**Shore School - Physical Education Centre-Mod-1 (SSD-7507-Mod-1)
Request for Additional Information**

I refer to the modification assessment for Shore School - Physical Education Centre Mod 1 (SSD-7507-Mod-1). After careful consideration, the Department requests that you provide the following additional information:

A1 DRAWING SHEET	Drawn: NC
Co-ordinated: NM	Scale: 1:200 @ A1
Project Architect: AS	Date: 27.05.16
Project Director: RL	Revision: 06
Drawing Number:	North:
A-DA-4090

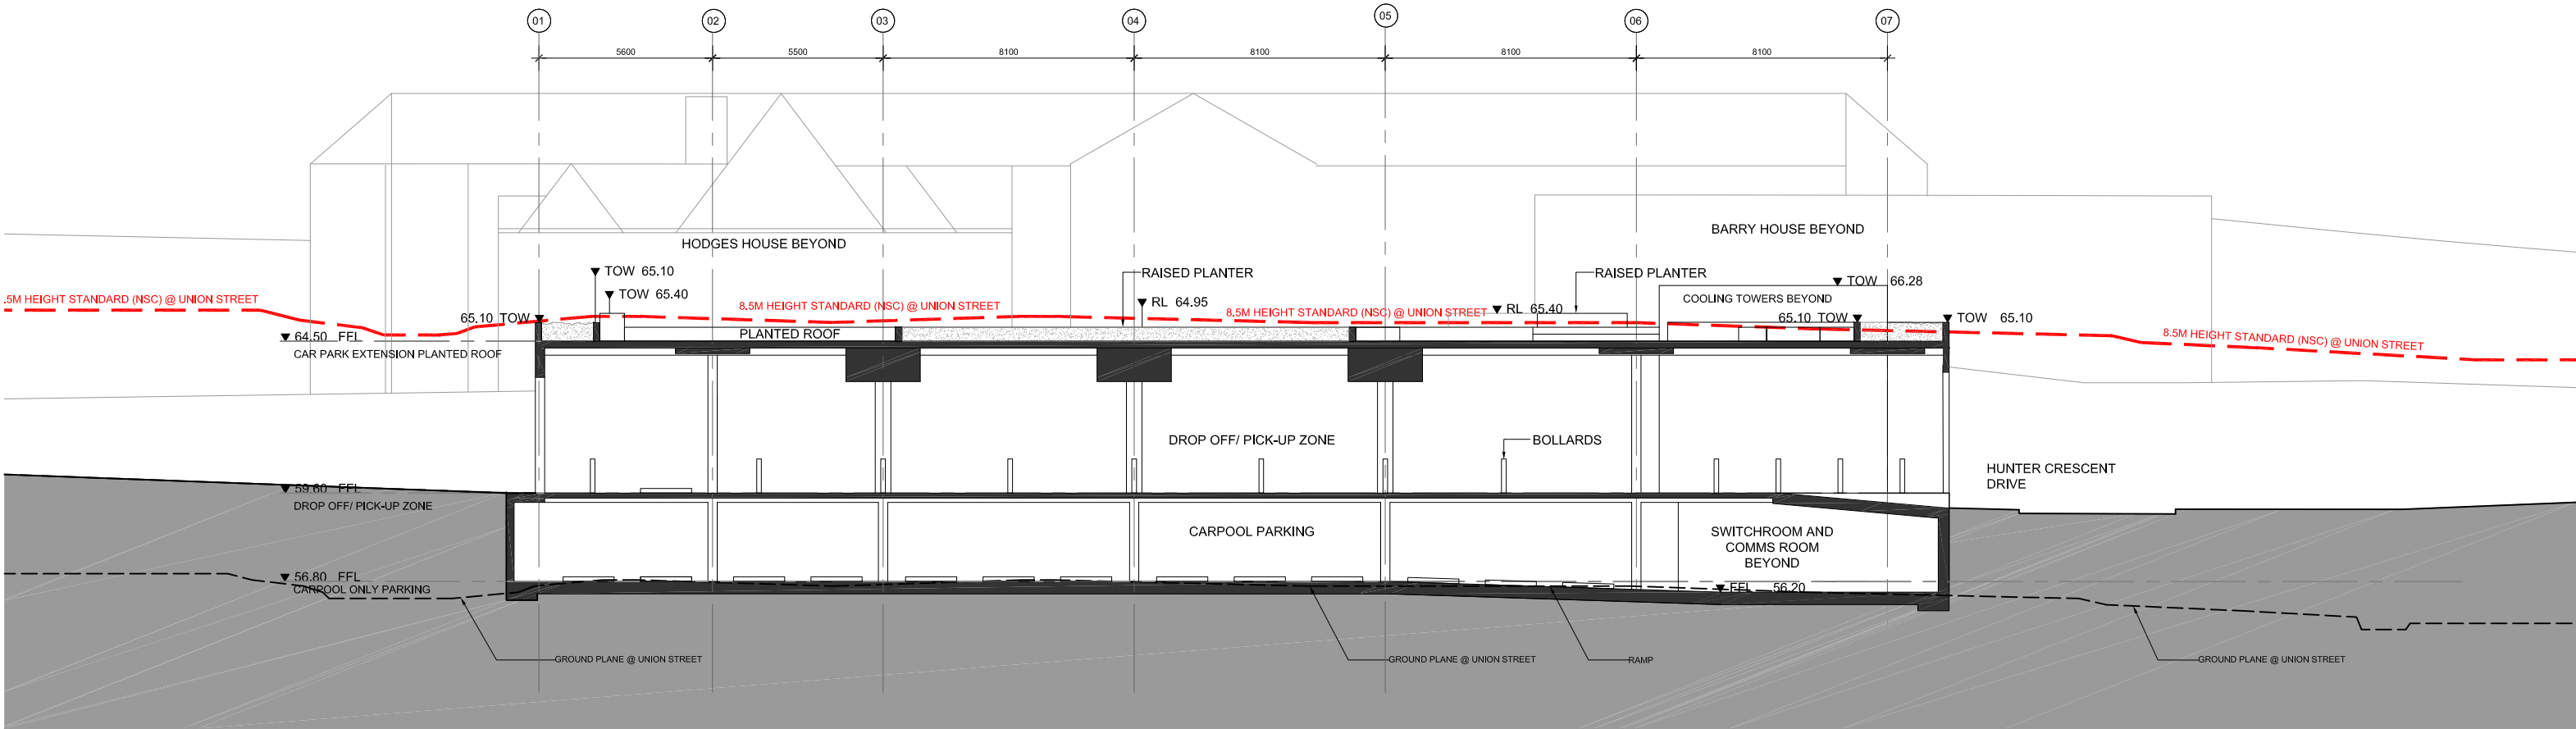
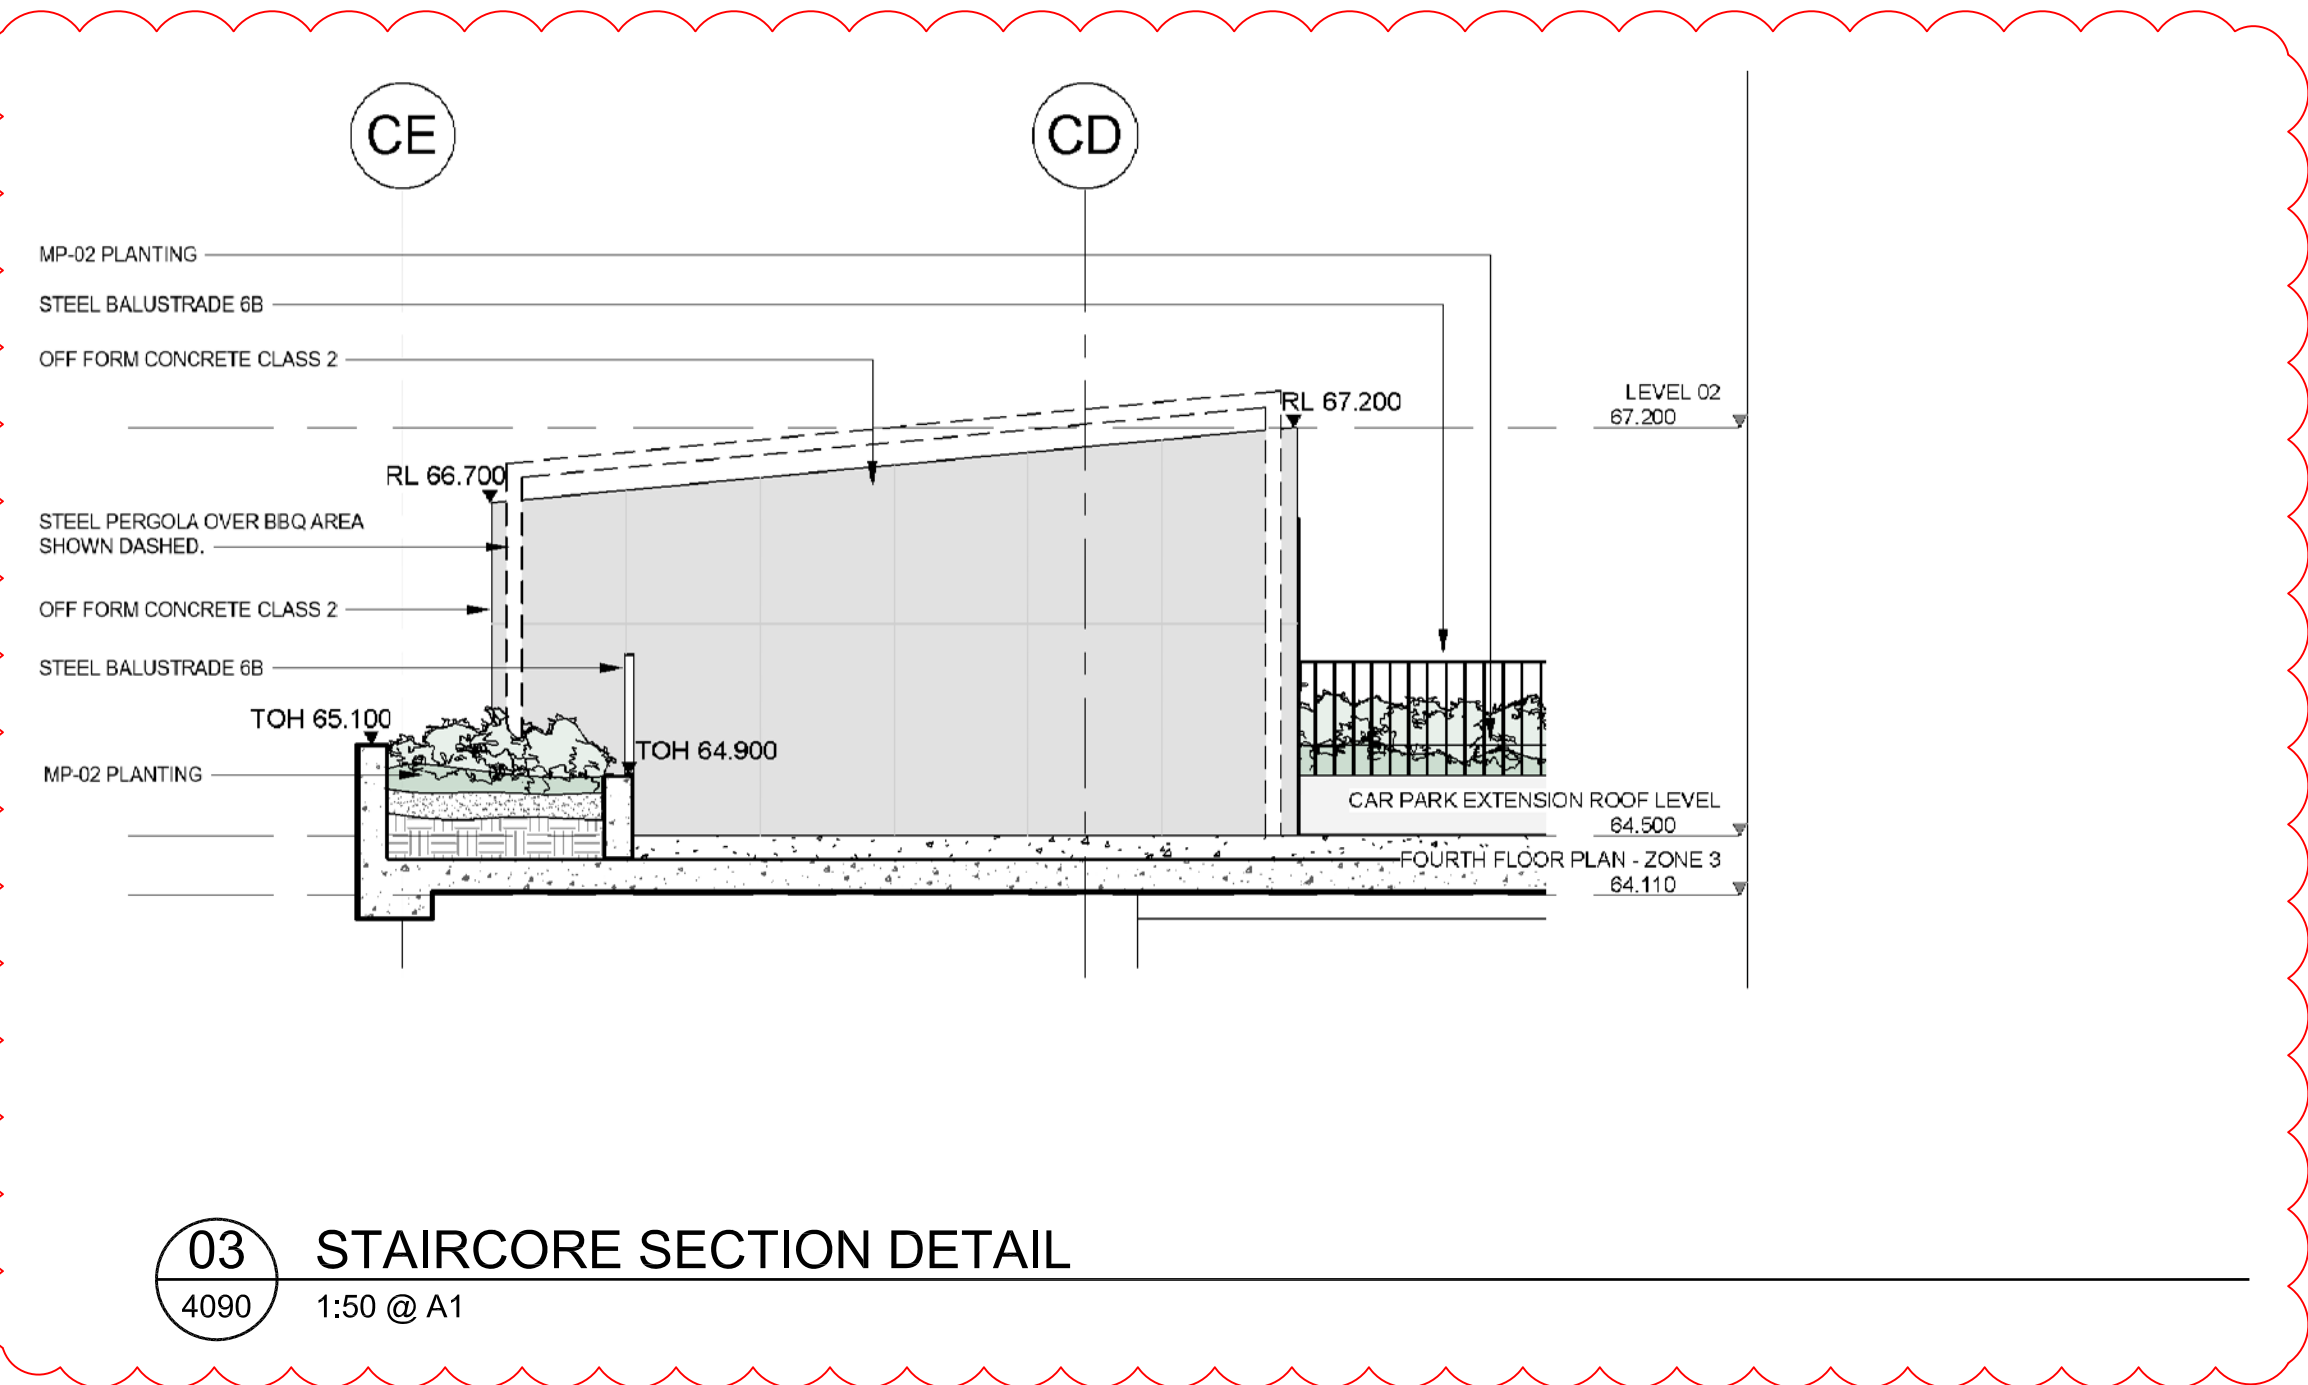
- Diagram 01 on Drawing No. A-DA-4090 provides a north-south (approx.) section through the cooling towers at the eastern end of the building. Please provide a cross section closer to the modification and identify the proposed changes;
- Diagram 02 on Drawing No. A-DA-4090 provides an east-west (approx.) section through the building to the north of the section of the building to be modified, and as such, doesn't show the modification. Please provide a cross section looking towards the modification; and
- Please also provide an annotation identifying the maximum building height on each of the sections and elevations.
